**STAGE 1 ROAD SAFETY AUDIT  
RESIDENTIAL DEVELOPMENT, WHITEHALL ROAD WEST, BIRKENSHAW  
DESIGNER'S RESPONSE**

The following table summarises the findings of the Stage 1 Road Safety Audit performed by Meraki Alliance regarding the proposed access and highway infrastructure serving the proposed residential development off Whitehall Road West in Birkenshaw and provides the Designer's Response to each point raised by the audit team.

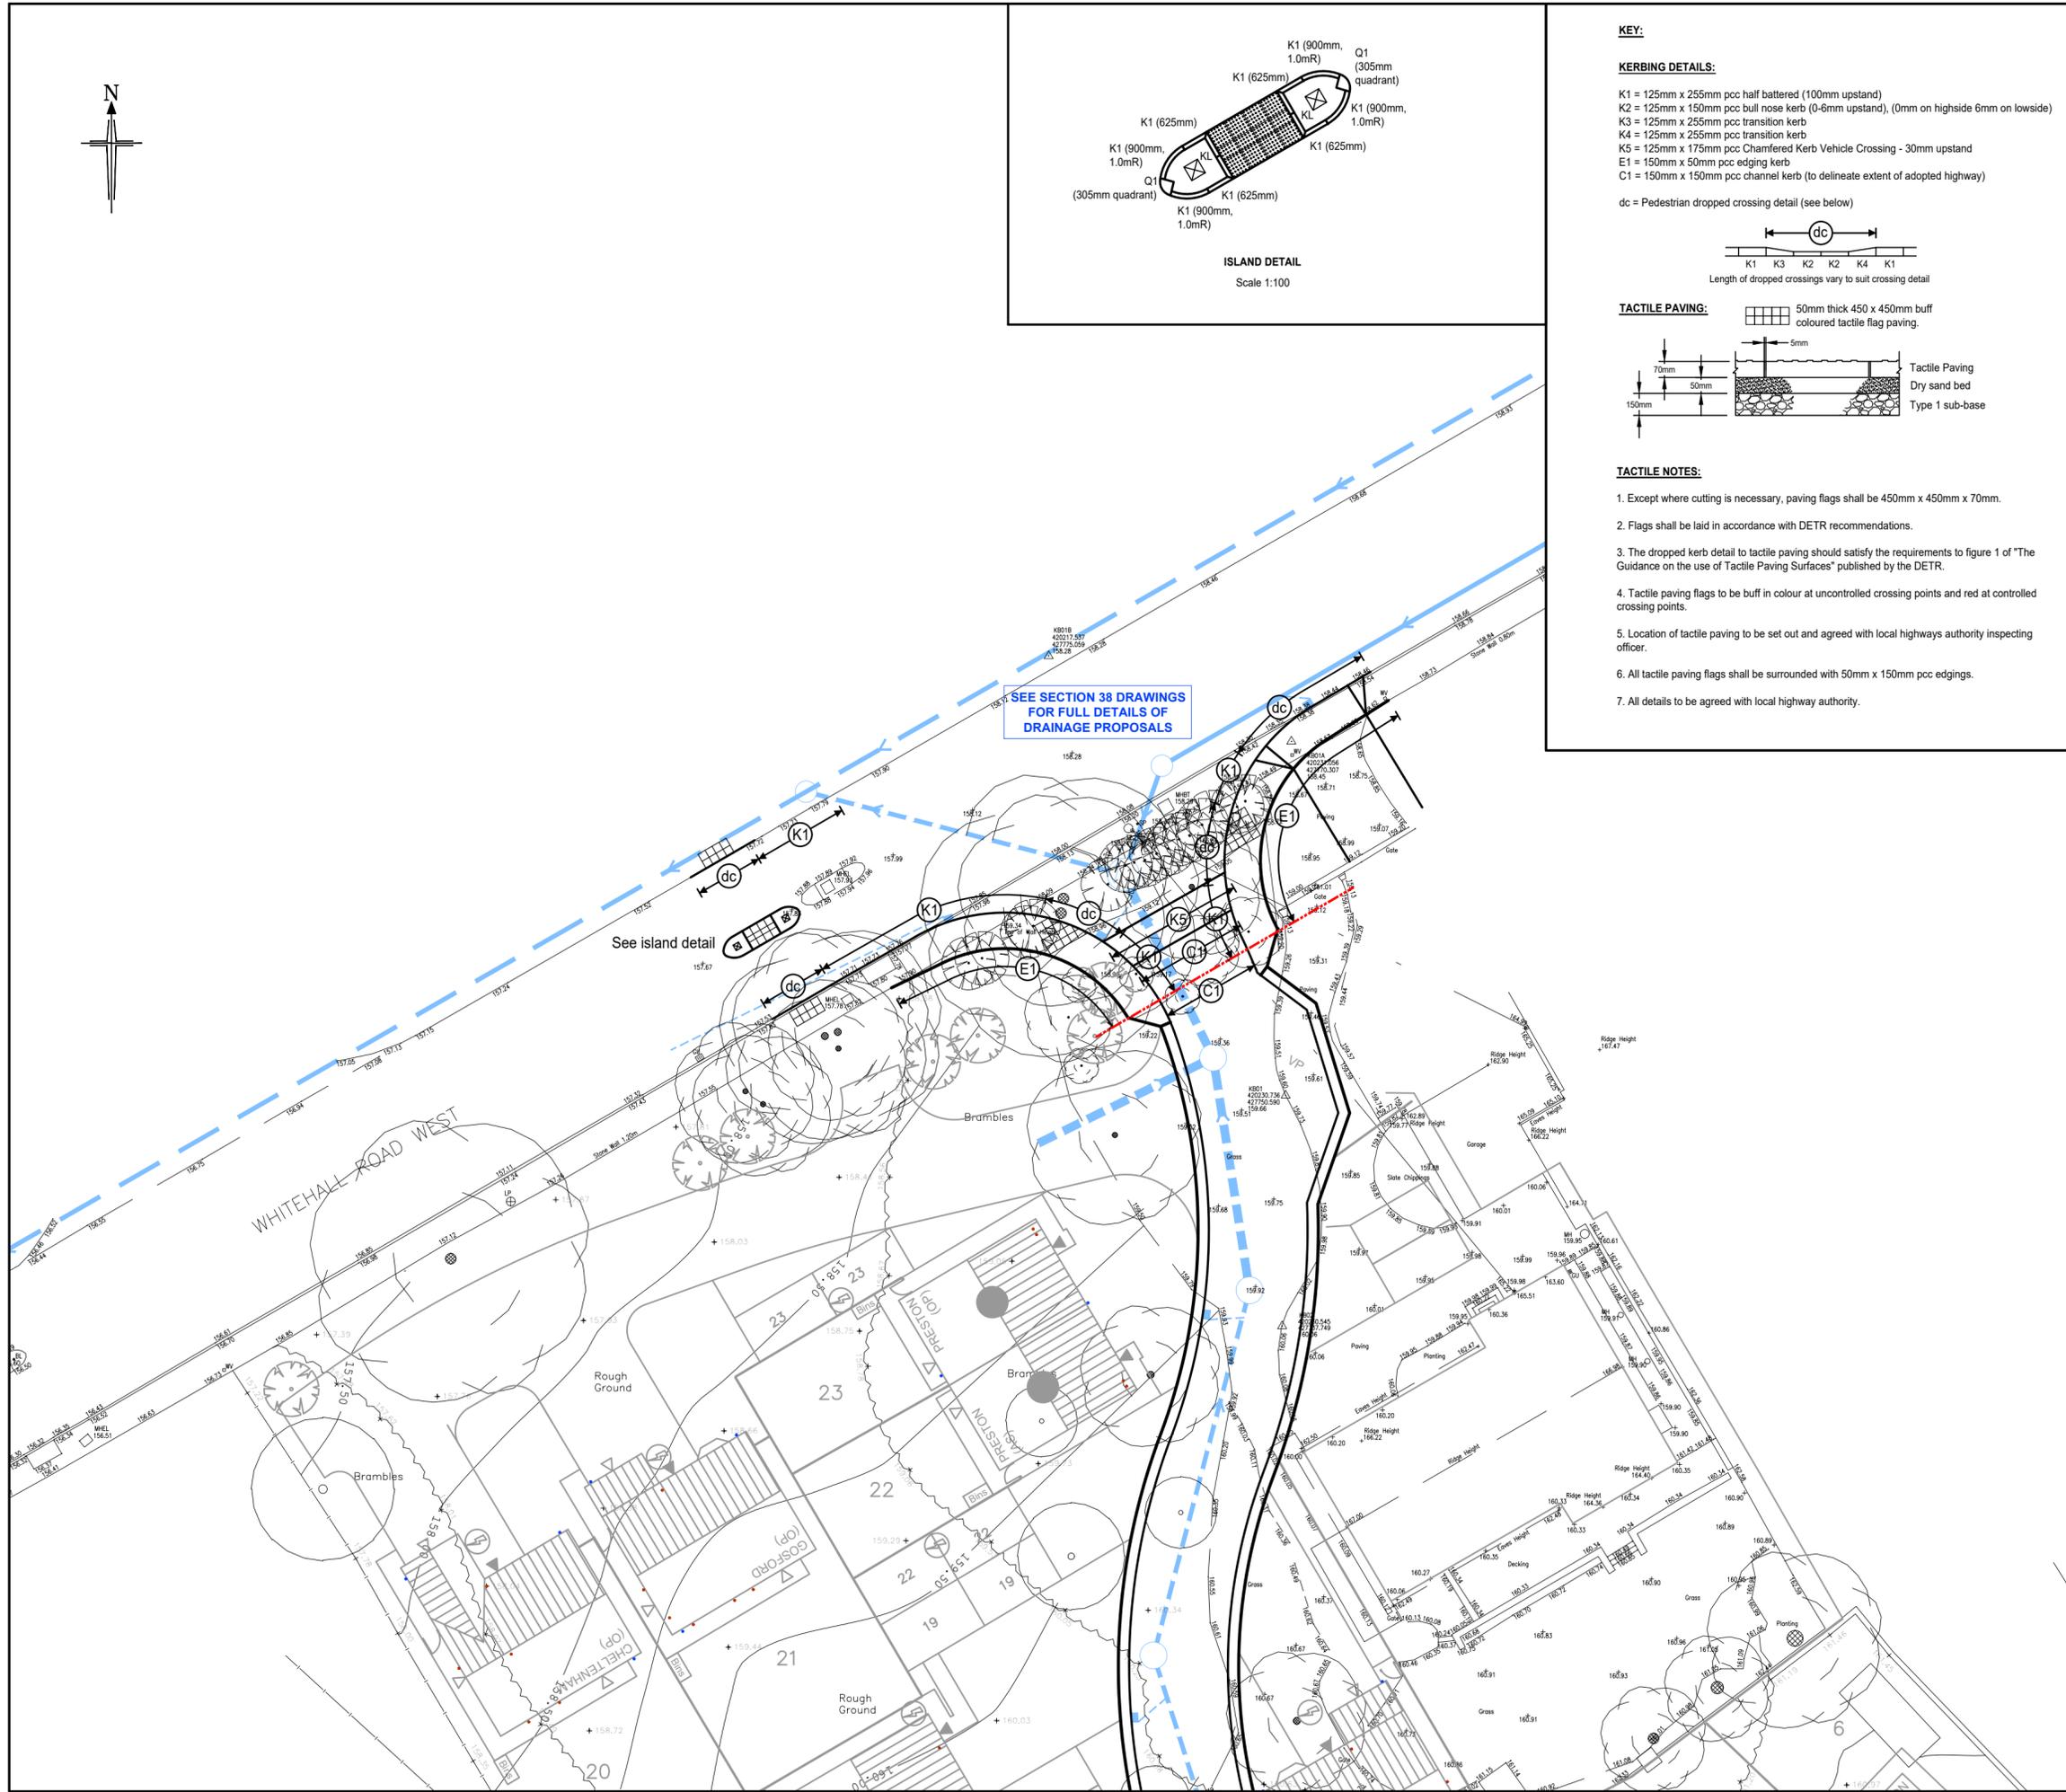
RSA Problem	RSA Recommendation	Design Organisation Response	Overseeing Organisation Response	Agreed RSA Action
<p><b>PROBLEM A</b> Relocated uncontrolled crossing Whitehall Road.</p> <p><b>Summary</b> Pedestrian refuge islands that do not provide sufficient width will increase the risk of pedestrian/vehicle collisions.</p> <p>It is proposed to relocate the existing uncontrolled crossing and central refuge to the south of the new access. The Audit Team noted that the pedestrian refuge is very narrow 1.2m. It is generally recognised the minimum width should be no smaller than 1.5m. Pedestrian refuge islands that do not provide sufficient width will increase the risk of pedestrian/vehicle collisions.</p>	<p>The Audit Team accept that this is an existing refuge and that it will simply be relocated like for like. However, the Audit Team still recommend that the size of the refuge is increased to 1.5m where possible.</p>	<p>There are 3 traffic islands on Whitehall Road between the proposed site access and the roundabout with Heathfield Lane providing uncontrolled pedestrian crossing points across Whitehall Road West. Each island is approximately 1.0m wide.</p> <p>The Designer acknowledges the current width of the traffic island, but that any increased island width would be provided on the balance of providing a bit more width for the occasional pedestrian standing in the middle of the carriageway crossing Whitehall Road West or reducing the available lane/carriageway width between the new island and kerb edge and therefore increasing the risk of side swipe type accidents between vehicles and cyclists passing the island at the same time.</p>

<p>On balance the Designer believes the width of the relocated/new island should be increased but to a maximum width of 1.20m.</p> <p>Refer to drawing 23/341/SK/003 rev B for details.</p>		
<p><b>PROBLEM B</b> Access junction Whitehall Road.</p> <p><b>Summary</b> Blocking back of traffic over the access could increase the risk of shunt and failure to give way type collisions.</p> <p>The Audit Team noted that traffic can queue back along Whitehall Road between the Heathfield Lane roundabout and the Birkenshaw Roundabout depending on time of day. This could lead to driver frustration especially when turning out of the development leading to drivers taking unacceptable risks increasing the risk of shunt and failure to give way type collisions.</p>	<p>It is recommended that "Keep Clear" markings are considered on Whitehall Road so that when traffic slows and begins to queue vehicles on Whitehall Road will give way.</p>	<p>Agreed. KEEP CLEAR road marking will be added to the proposed access arrangements.</p> <p>Refer to drawing 23/341/SK/003 rev B for details.</p>
